Rezoning Transportation Analysis

Petition Number: 2021-078

General Location Identifier: 02962126

| Date | Description |
|------------|---------------------|
| 08-02-2021 | First Review (DBS) |

SHEET
REZONING PLAN
RZ.01

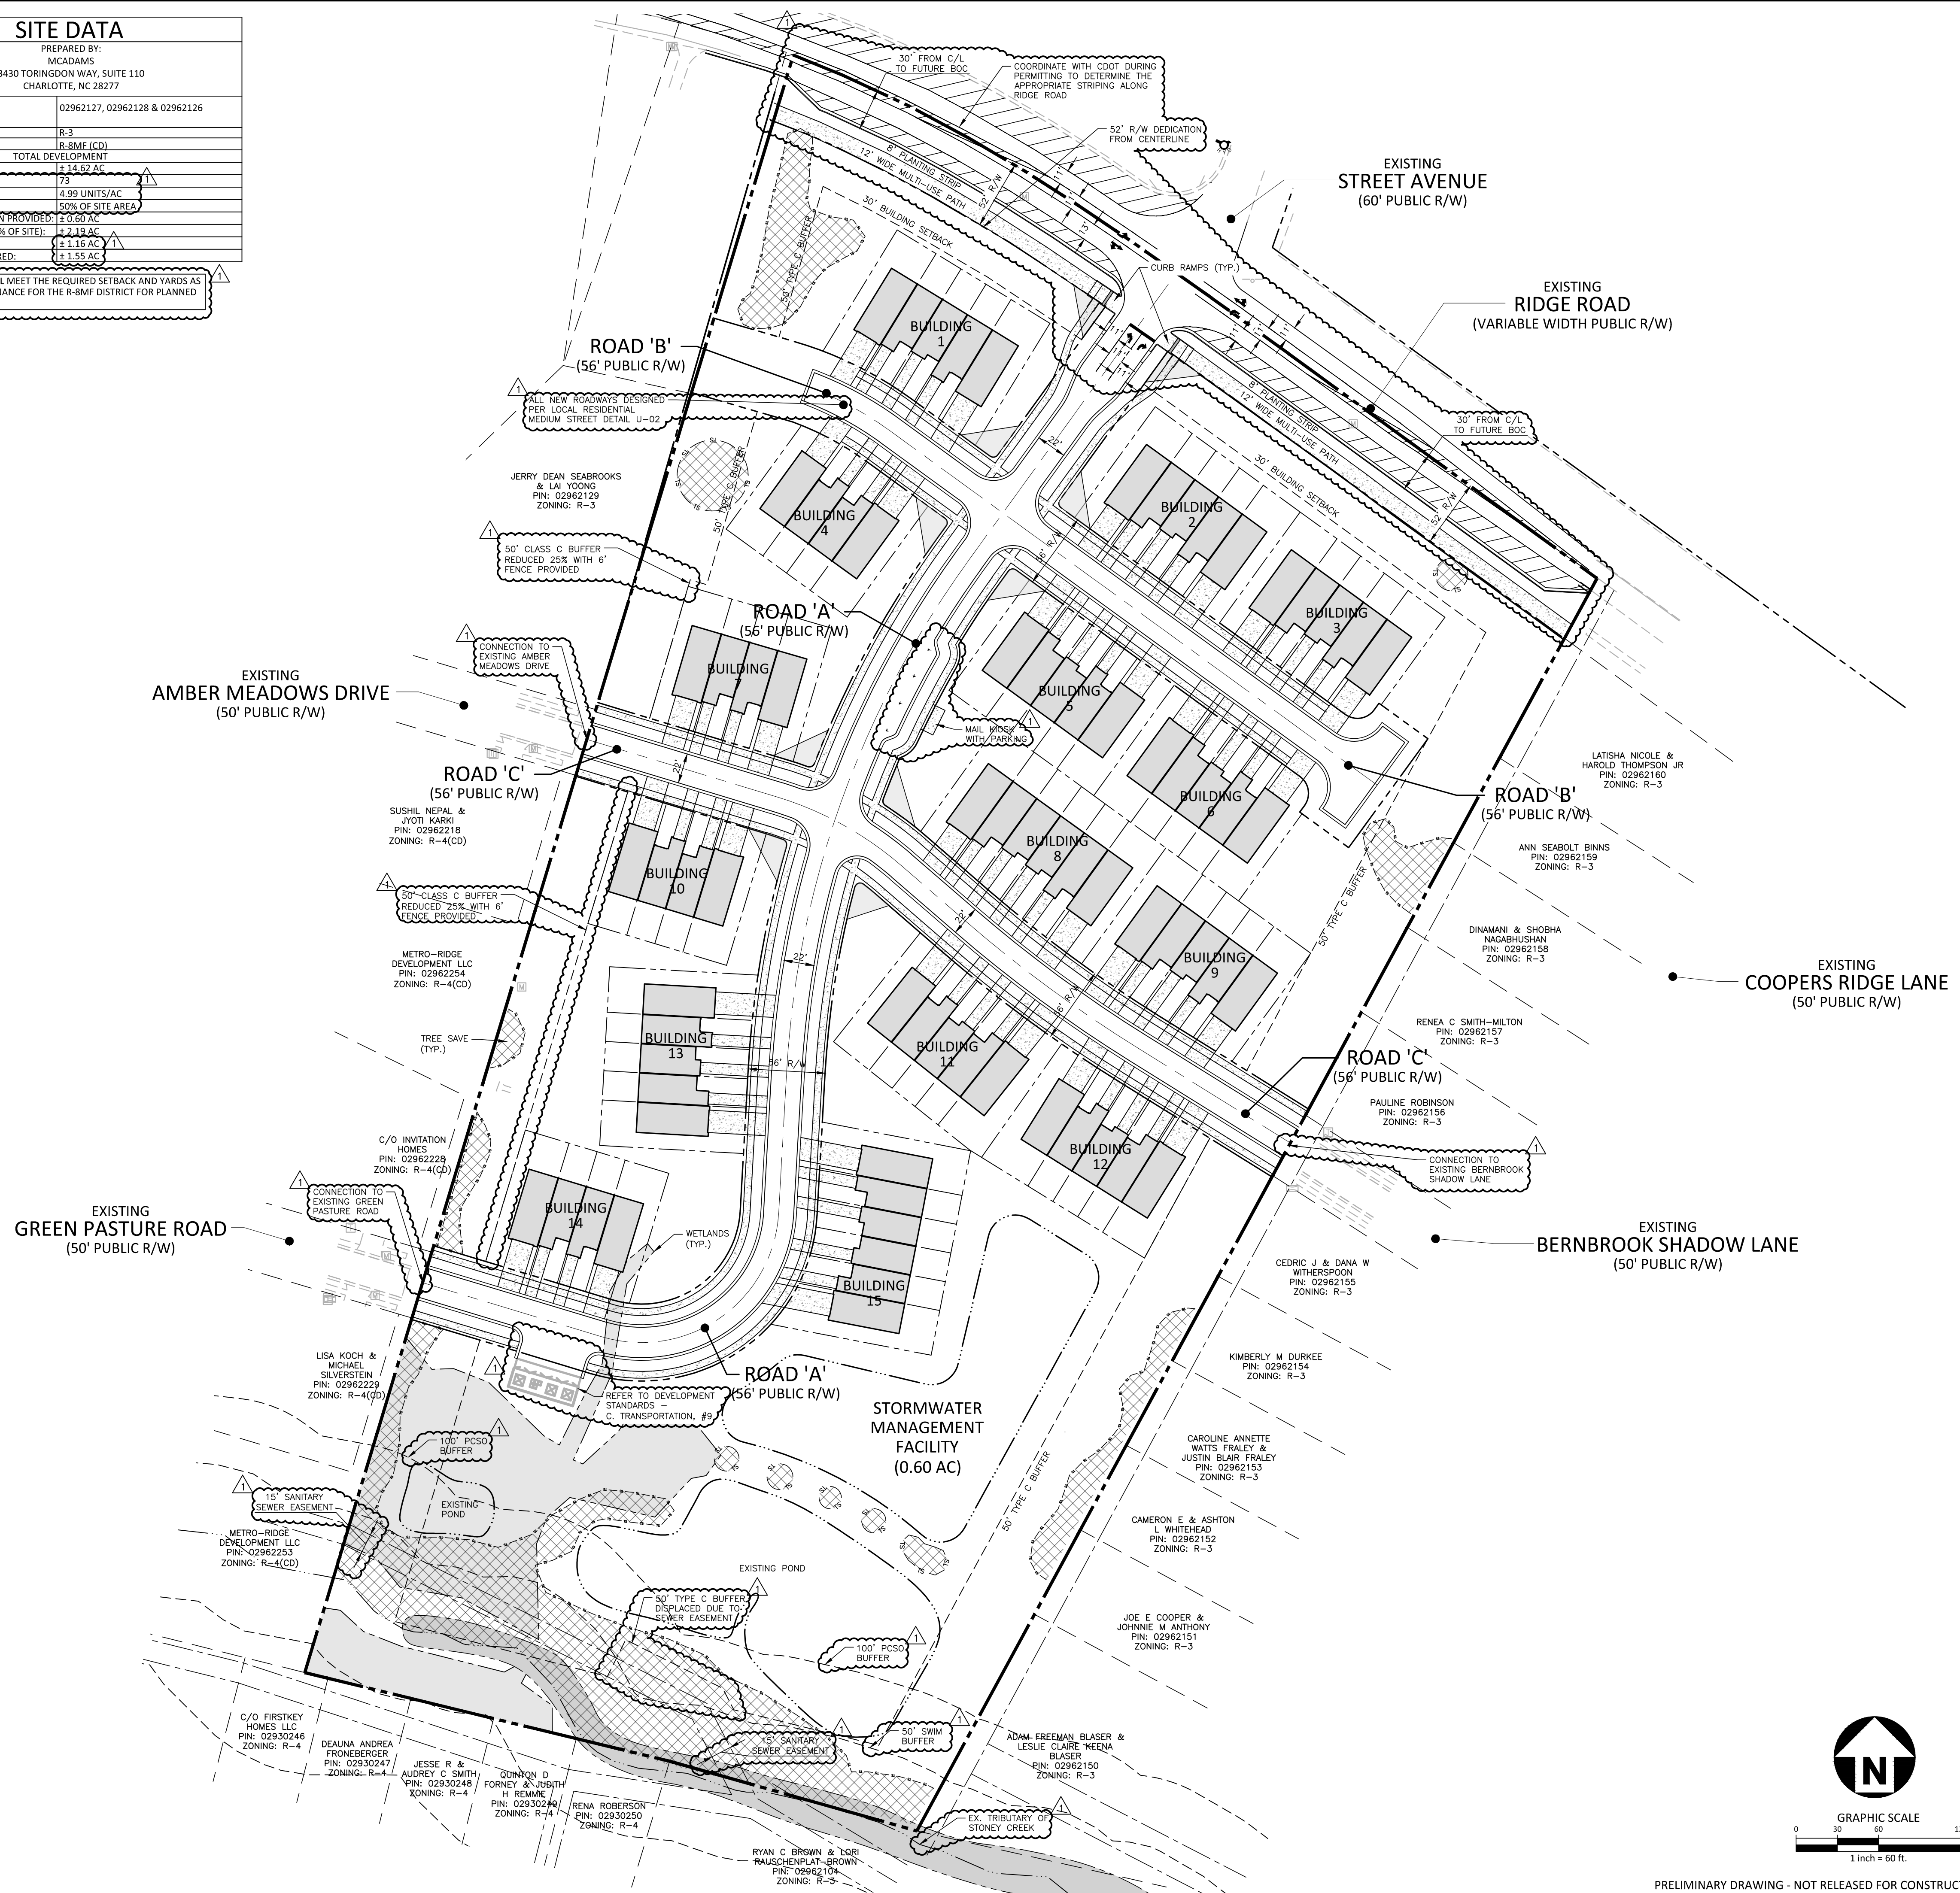
~~**Ridge Road:** Back of curb and gutter will be established at 30 feet from existing Ridge Road centerline. Label and dimension the curb and gutter from the centerline.~~

3. ~~Revise site plan and conditional note(s) to commit to dedicate 52 feet right of way from the road centerline. The site plan shall label and dimension the right of way from the road centerline.~~

4. ~~The site plan shall label and dimension the multi-use path from the centerline of Ridge Road. Revise site plan to include these dimensions and labels.~~

5. ~~Add note to site plan committing to coordinating with CDOT during permitting to determine the appropriate striping along Ridge Road.~~

6. ~~Revise site plan and conditional note(s) to commit to connecting new streets to three adjacent stub streets.~~

7. ~~Revise site plan to include two curb ramps at each corner of each public street intersection.~~

8. ~~Revise site plan to reflect Ridge Road left turn lane widths of 11 feet.~~

9. ~~Revise site plan to dimension lane widths at the development approach to Ridge Road. Appropriate pavement marking will be coordinated with CDOT during permitting.~~

- ~~10. Revise site plan to add labels to all proposed public streets and the appropriate CLDSM standard to be used.~~
- ~~11. A site plan note(s) specifying dedication and fee simple conveyance of all rights-of-way to the City before the site's first building certificate of occupancy is issued is needed. CDOT requests rights-of-way set at 2' behind back of sidewalk where feasible.~~
